Parks and Wildlife

June 05, 2017

El Paso County: Development Services Department
ATTN: Kari Parsons, Project Manager
2880 International Circle Suite 110
Colorado Springs, CO
Re: SP-17-002 - Meadowbrook Crossing Preliminary Plan

MEADOWBROOK CROSSING PRELIMINARY LANDSCAPE PLAN

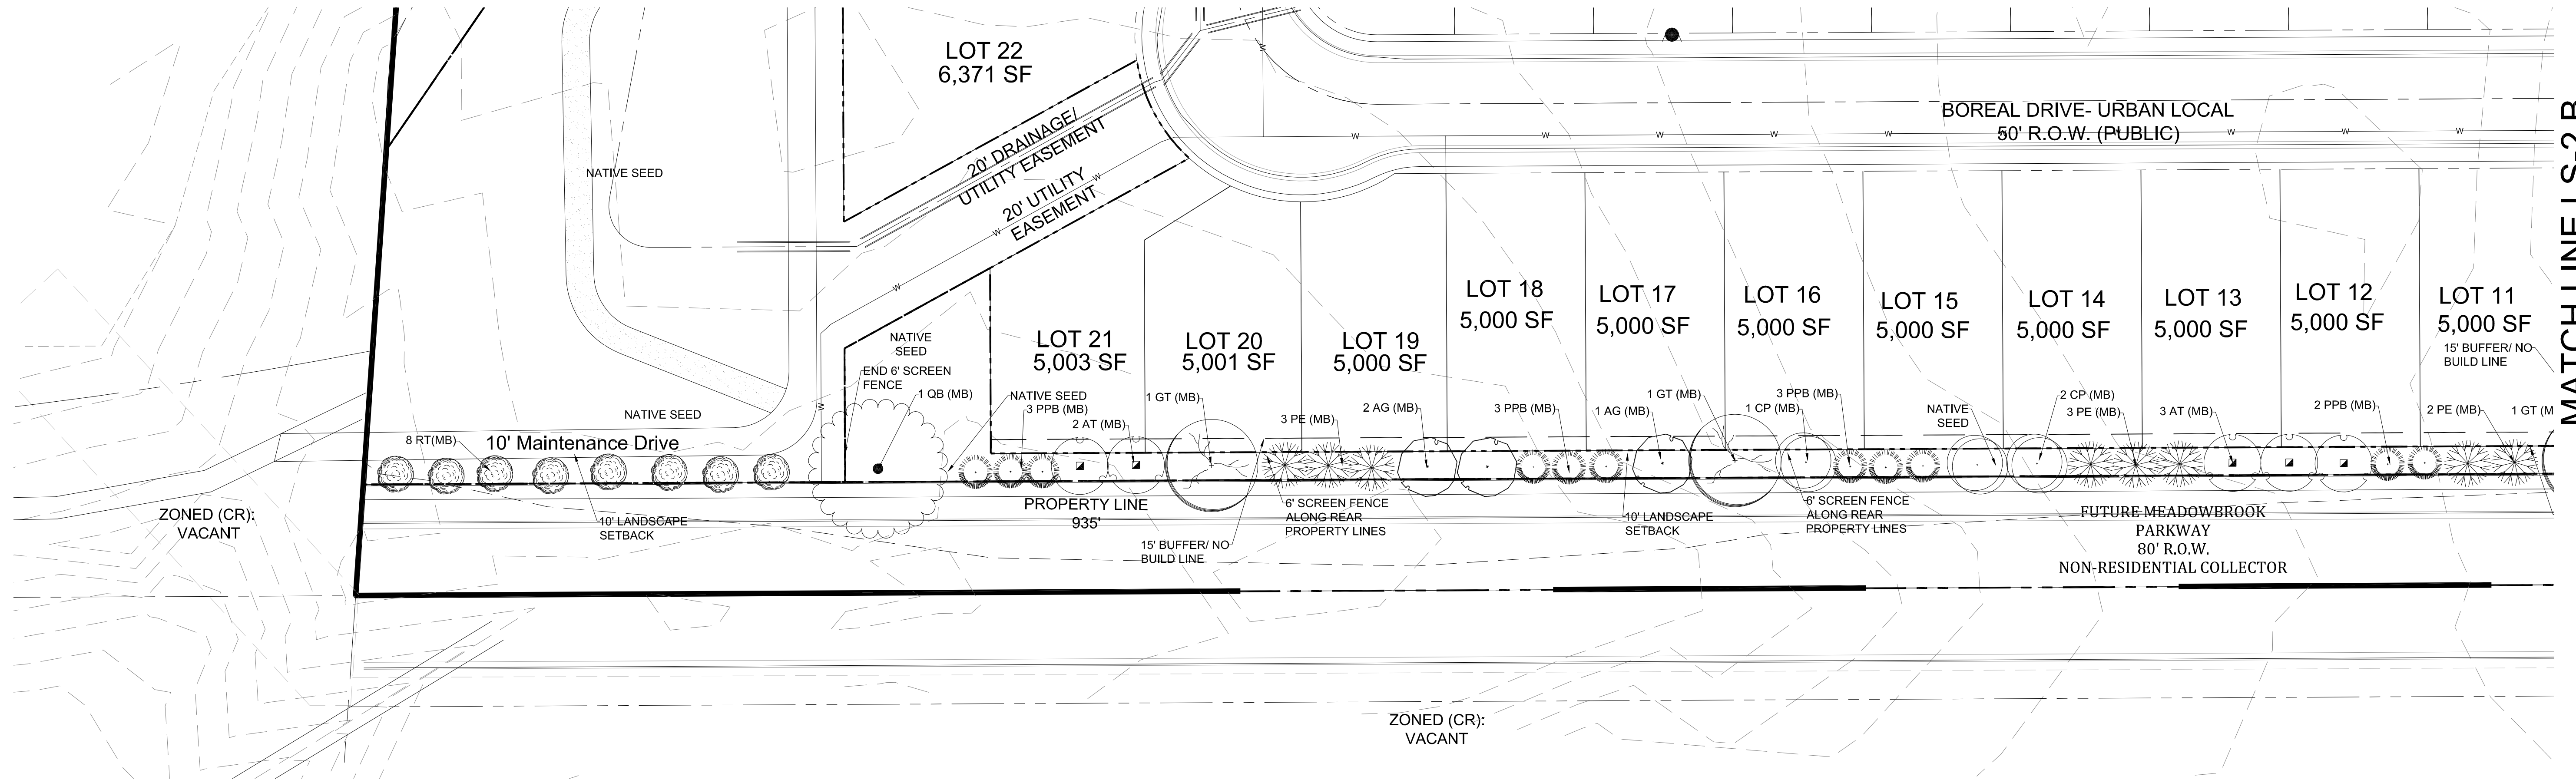
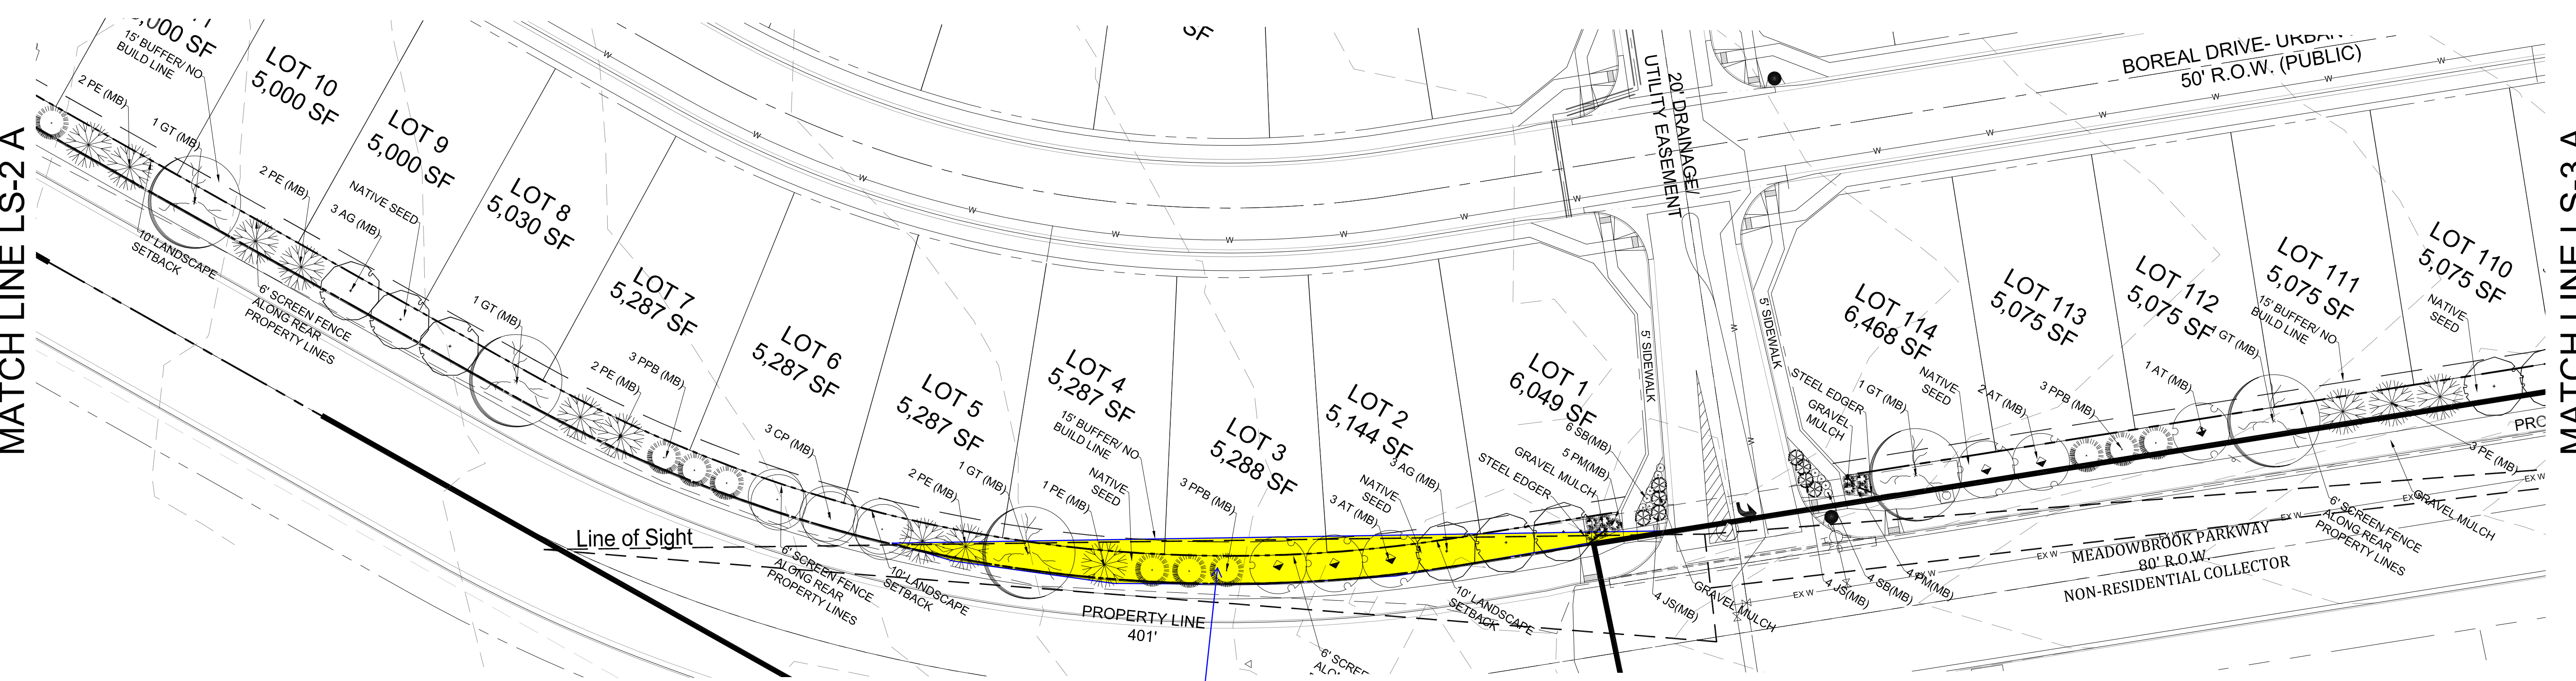
Construction even near riparian habitats can have downstream effects, such as increased sedimentation and erosion. If bank stabilization is not completely necessary in an area, we recommend leaving it in its natural state. Disturbance to soil can lead to introduction of invasive plant species and CPW recommends the development and implementation of a noxious weed control plan for the site. Care should be taken to avoid the spread of noxious weeds, and all construction equipment should be cleaned prior to leaving the site. CPW recommends that in places where vegetation is removed, a native seed blend is used that matches the surrounding vegetation types as accurately as possible. All disturbed soils should be monitored for noxious weeds and noxious weeds should be actively controlled until native plant re-vegetation and reclamation is achieved. All landscaping in the developed area should be comprised of native species, and CPW recommends against using non-native plants or noxious weeds.

Some care should be taken with species choice to prevent the attraction of unwanted wildlife into the development area. Information on plant species consumption by specific wildlife species is available through CPW. Regarding the open space in the plan, using native species with high food and cover values in an open space area large enough to maintain a viable movement corridor, and native plants with little food and cover value in the developed area, wildlife will be concentrated in areas that minimize conflict and optimize wildlife watching

5. When landscaping lots, it is strongly recommended that native vegetation be used that wildlife is less likely to be attracted to. Planting of trees and shrubs that are attractive to native ungulates should incorporate the use of materials that will prevent access and damage (fencing, tree guards, trunk guards, etc.).
